A/229/21/HH & A/230/21/L

The White Lodge, Rectory Lane, Angmering, BN16 4JU

Erection of single storey side extension. (This application may affect the character and appearance of the Angmering Conservation Area and a Listed Building).

Ground Floor Plan
as proposed

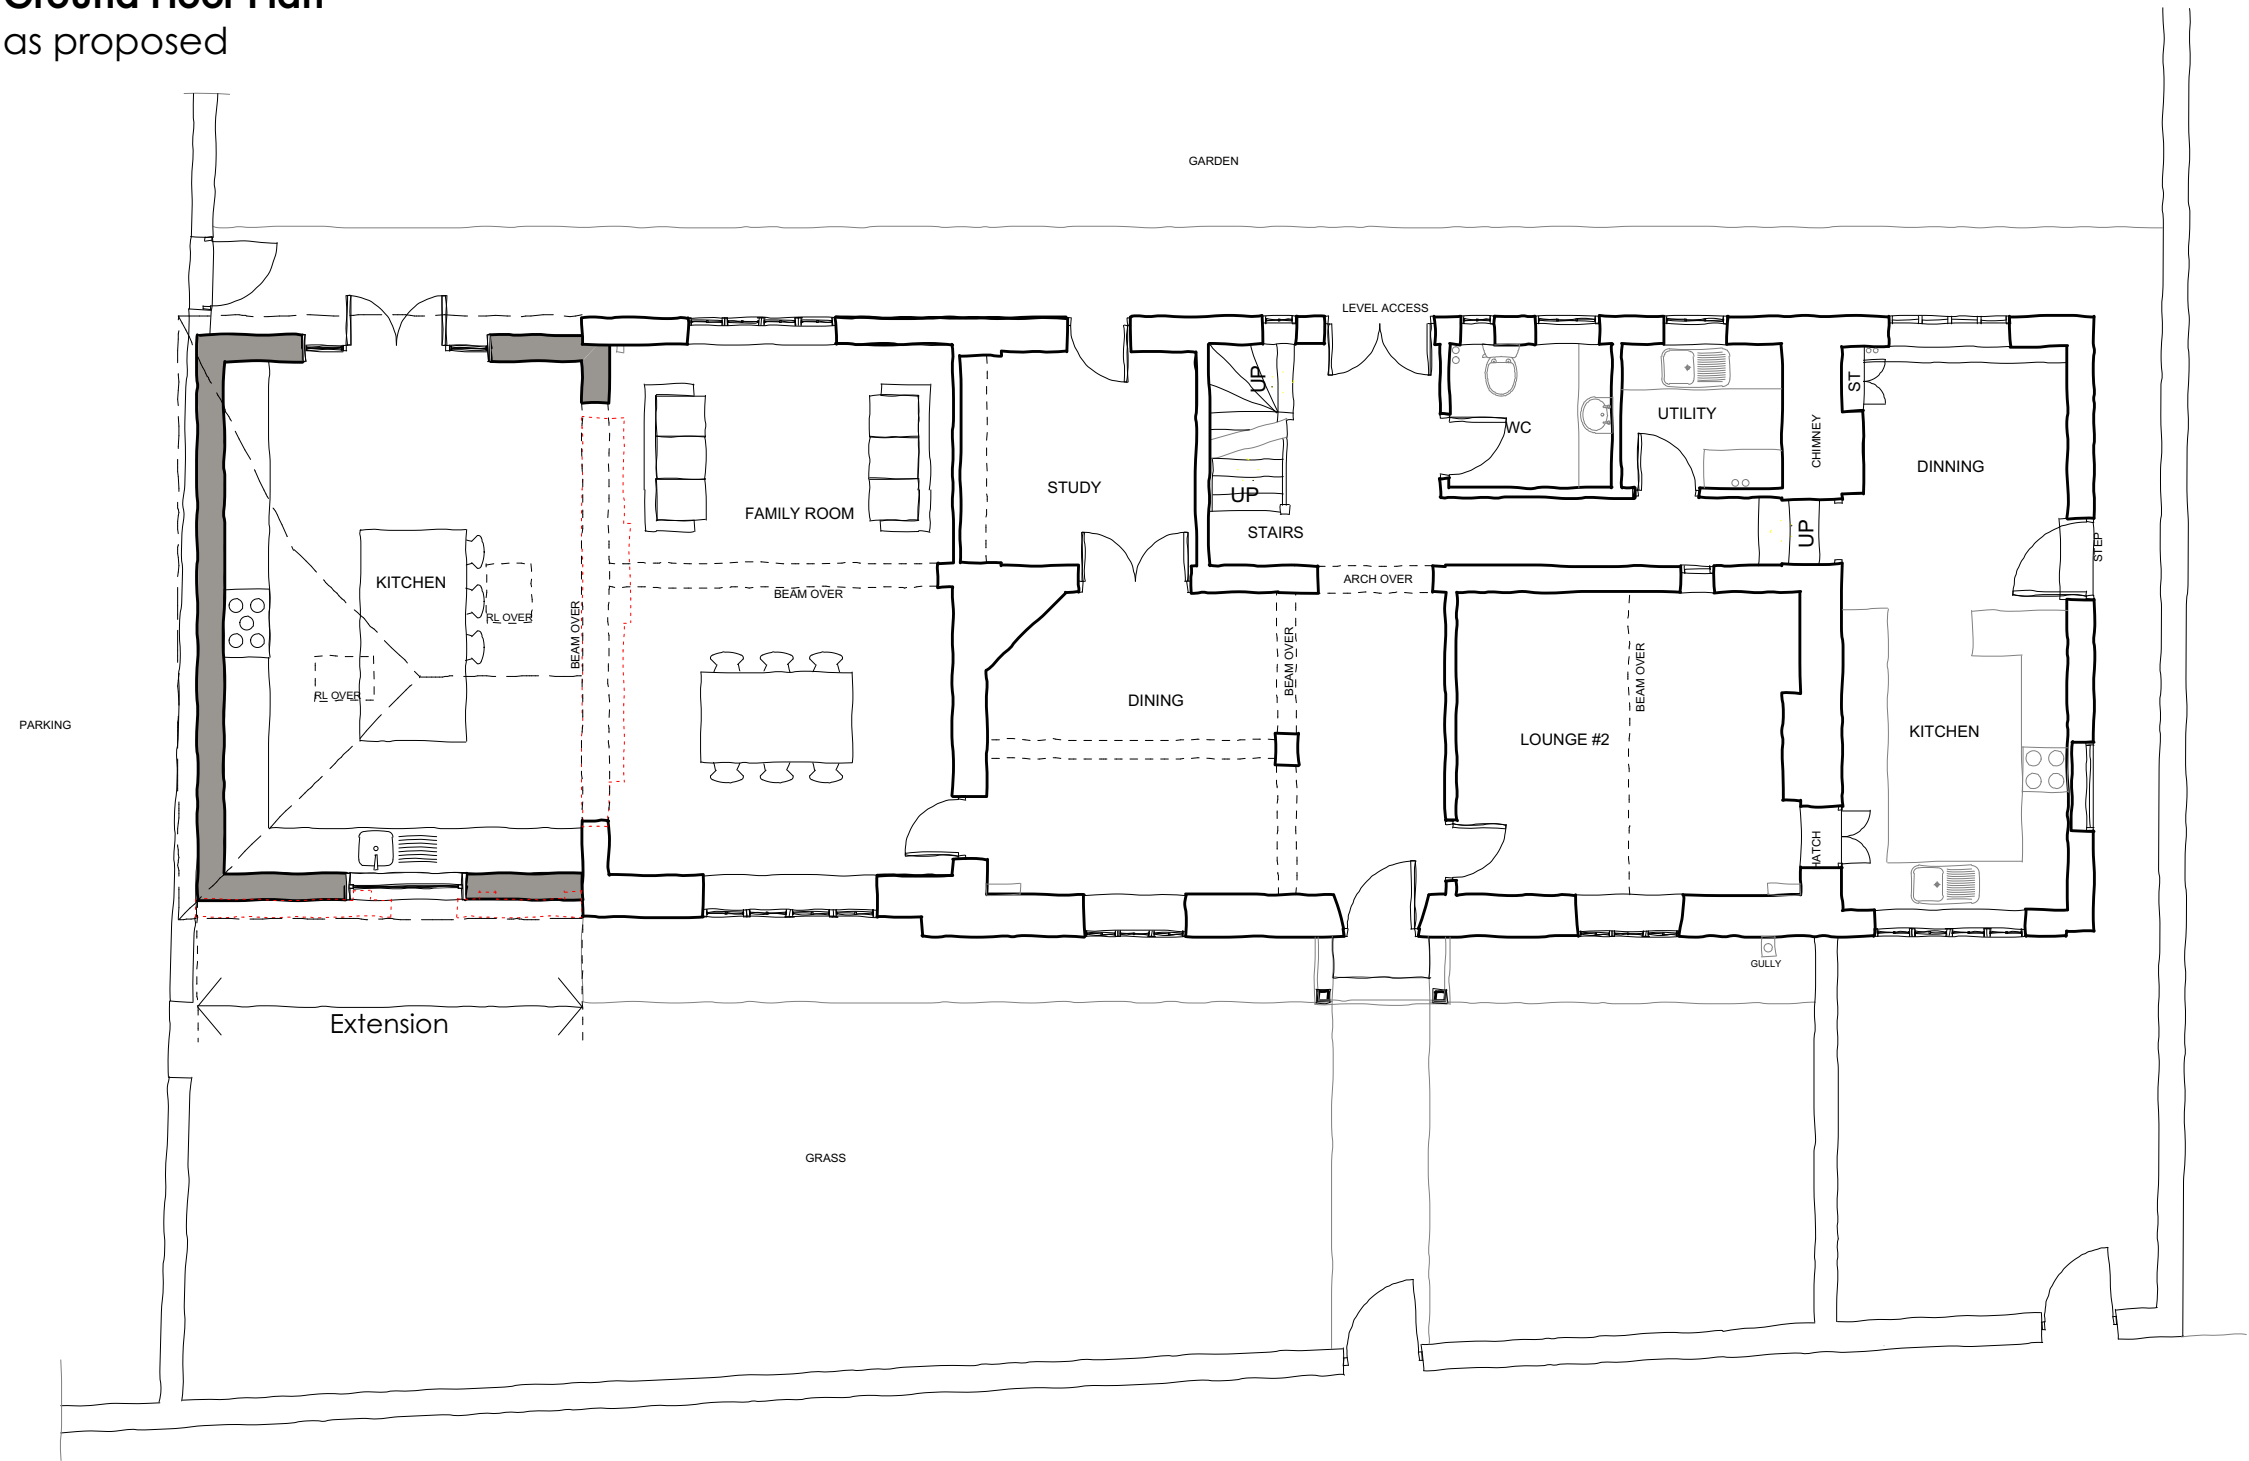
The proposal is for a single storey side extension which will run from the front elevation to the rear. I note that the intention is to provide a larger kitchen/living/dining space which the applicant considers to be of an appropriate scale of the remainder of the house. The width of the extension appears to be contained by an existing wall, which at present provides enclosure for a small courtyard area. The location is the furthest away from the older parts of the building, which is positive. It is to be set slightly behind the existing elevations and will require the removal of a large section of the existing Victorian side wall of the house.

The design of the extension will match the host dwelling and being constructed from materials appropriate for it. It will also be set back from the front and rear elevation which helps to make it subservient, which is positive. Whilst, a fairly large area of Victorian walling would be removed as part of the proposal, it is noted that the plans include significant nibs of the existing end elevation which would act as a record of the development of the building. This can be enhanced further through the use of a down stand as part of the works to the wall.

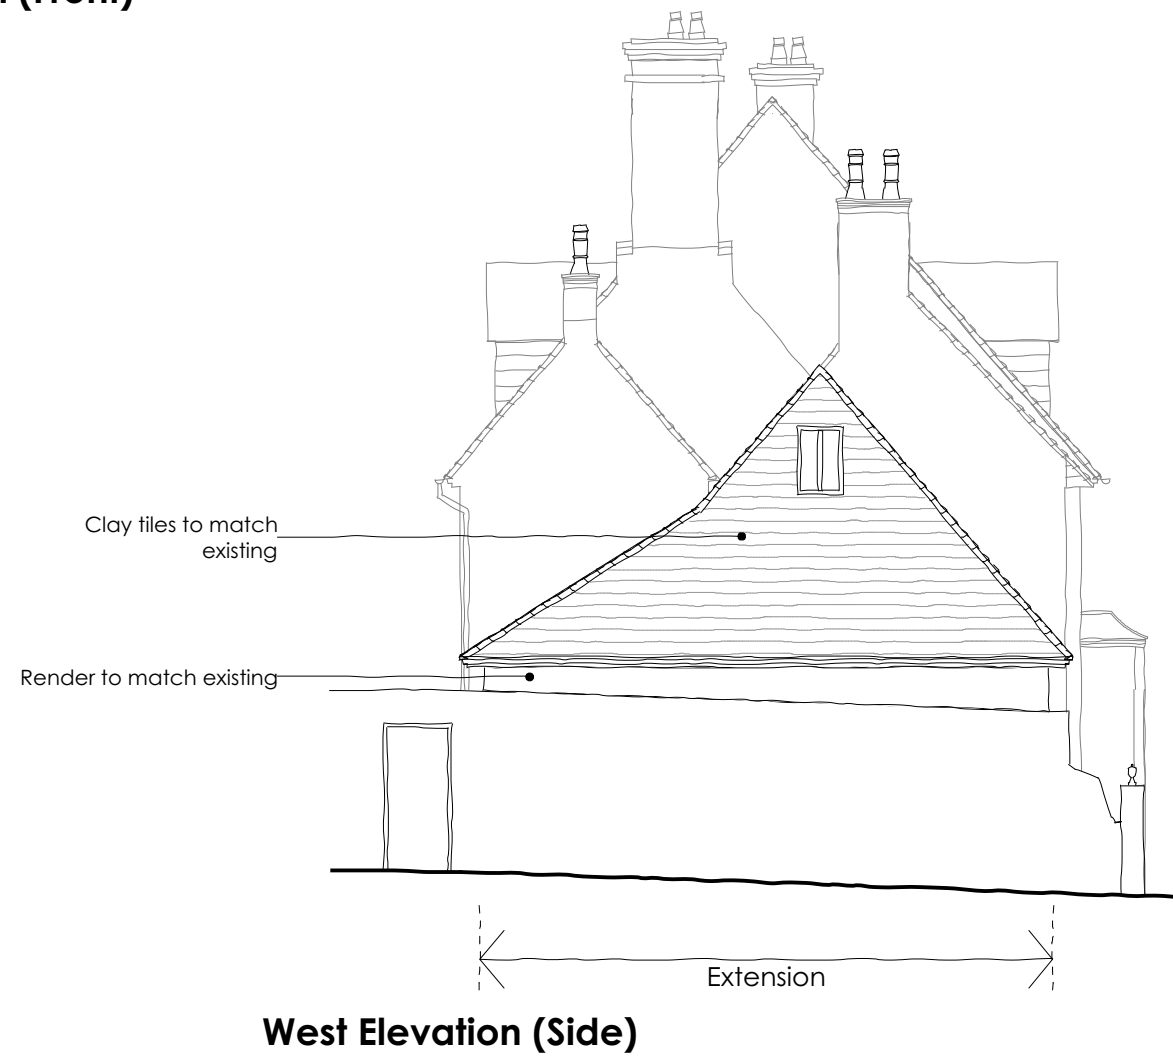
Overall, I am of the opinion that the proposal is acceptable and would reflect the character and appearance of the existing building and those in the local area. I would want details of the windows and doors to be provided to the LPA, so as to ensure that they are appropriate for both the listed building and conservation area. This can be provided by way of conditions and should be provided in the form of drawings and sections to an appropriate scale, and include elements such as the materials, finishes, details of the frame, glazing and glazing bars, operating mechanisms and depths of reveals.
